ASSESSMENT REPORT

Section 96(1A) Modification Prestons Industrial Estate (SSD 7155 MOD 2) Modifications to Warehouses 3 and 4

EAST ELEVATION -2 Years
WAREHOUSE 4
1 : 300 scale

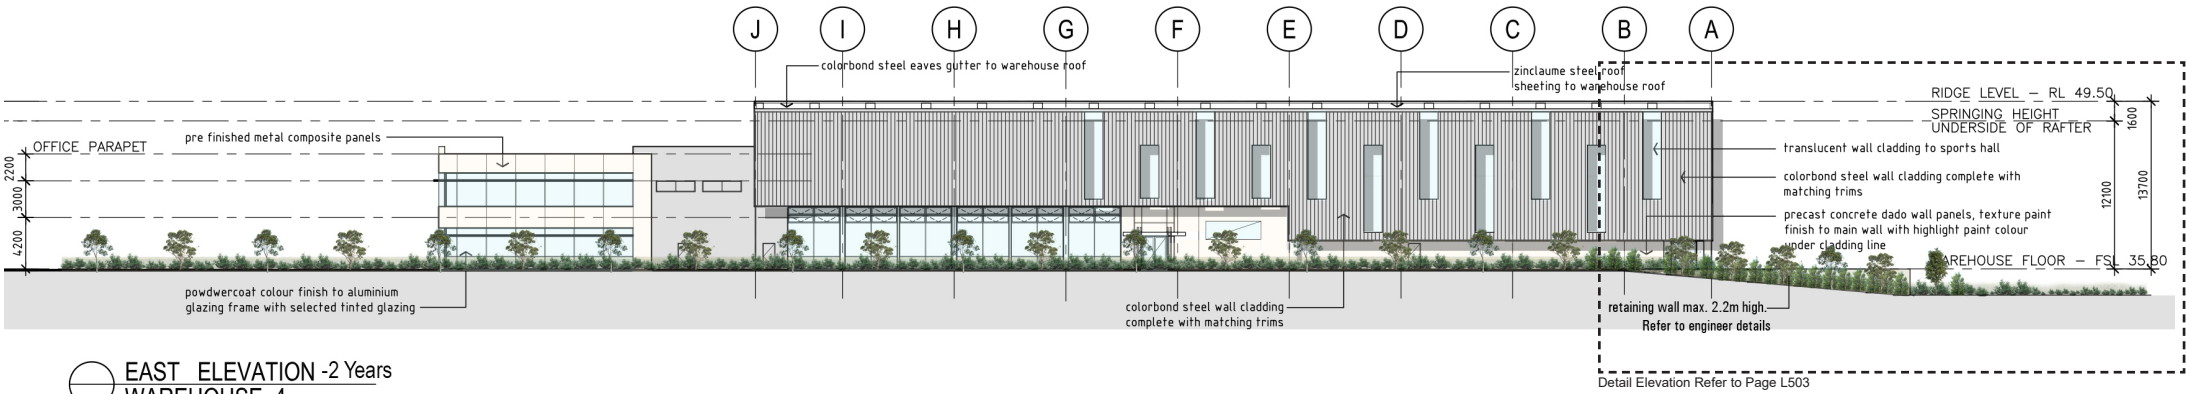
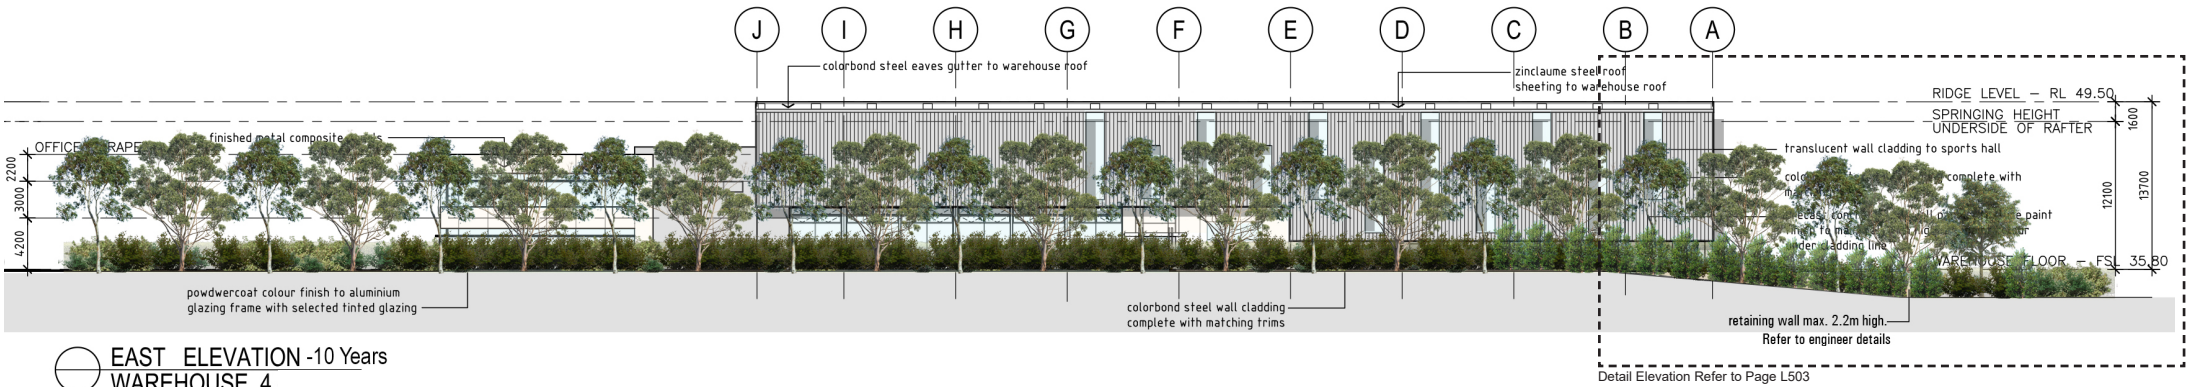
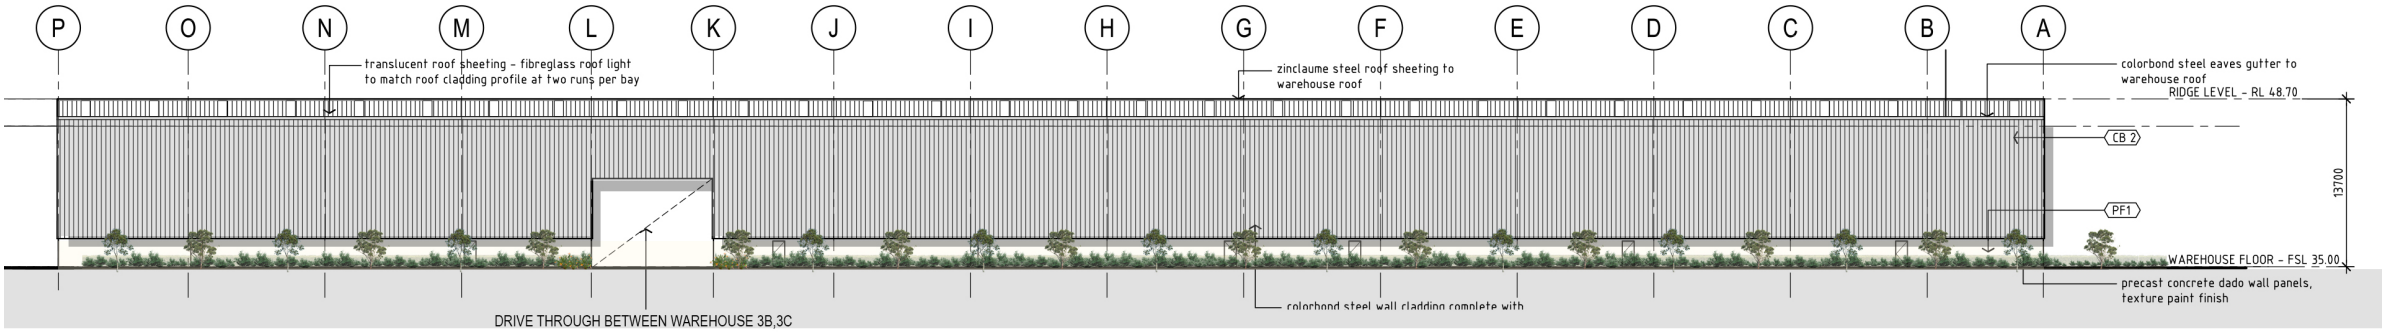
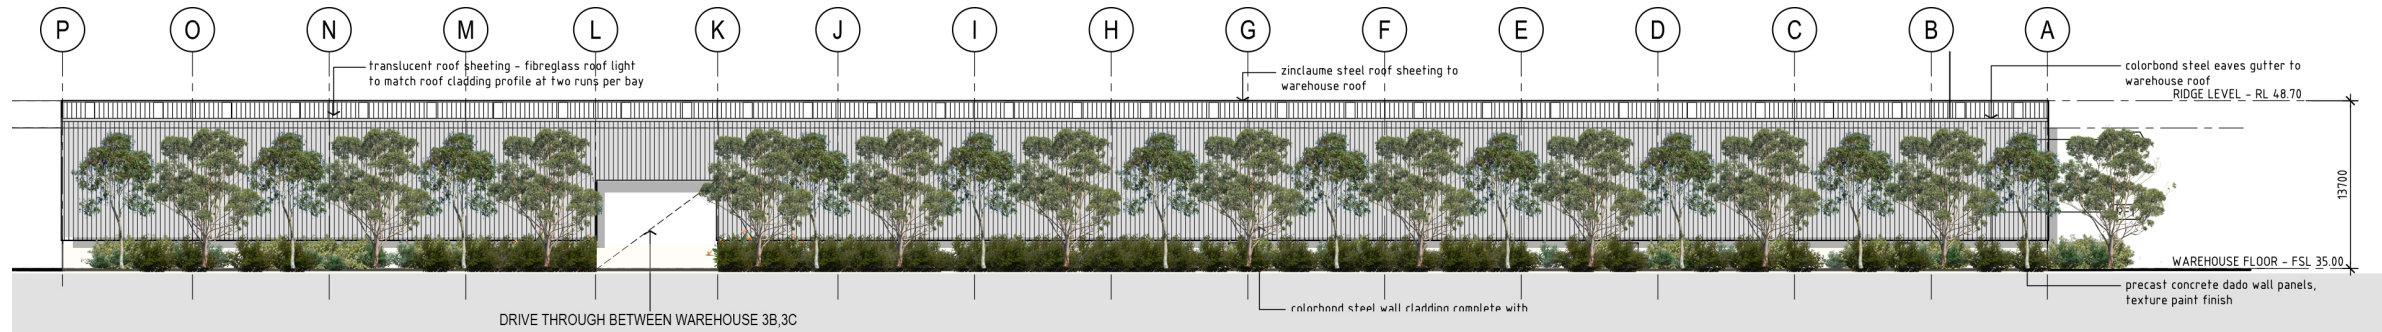
- visual bulk along the Bernera Road frontage.

The modification application seeks to reduce the width of landscaping from 6 m to 2 m along part of Bernera Road adjacent to Warehouse 4 (see **Figure 6**). The reduction in landscaping adjacent to Warehouse 4 is sought to increase the provision of car parking required for a recreation facility (indoor) use of the building which will be subject to a separate DA with Council. The remainder of Bernera Road will feature a minimum 6 m wide landscaped setback. A new 2.6 m high retaining wall is also proposed along a portion of Bernera Road, adjacent to the north-eastern corner of Warehouse 4. The 20 m wide landscaped setback along the Kurrajong Road frontage which is directly opposite the residential area to the south will be preserved.

The Applicant provided landscaping drawings prepared by Habit8 Pty Ltd to show the proposed amendments to the landscaping and species composition along the Yarrunga Street and Bernera Road frontages. At the Department's request, the Applicant also provided a photomontage of the Bernera Road frontage as well as detailed plans to demonstrate the potential visual impact to the Bernera Road elevation. The view of Warehouse 4 from Bernera Road with matured native landscaping is shown in **Figure 9**.

The existing conditions of consent of SSD 7155 require that the landscaping is implemented prior to the operation of each stage of the development, to ensure visual impacts are minimised and will be retained by this modification application.

The Department's assessment concludes the existing conditions of consent of the SSD 7155 ensure visual impacts will be adequately ameliorated. The proposed modifications to building setbacks and species composition will ensure much of the development will be visually screened and will not have a significant visual impact.
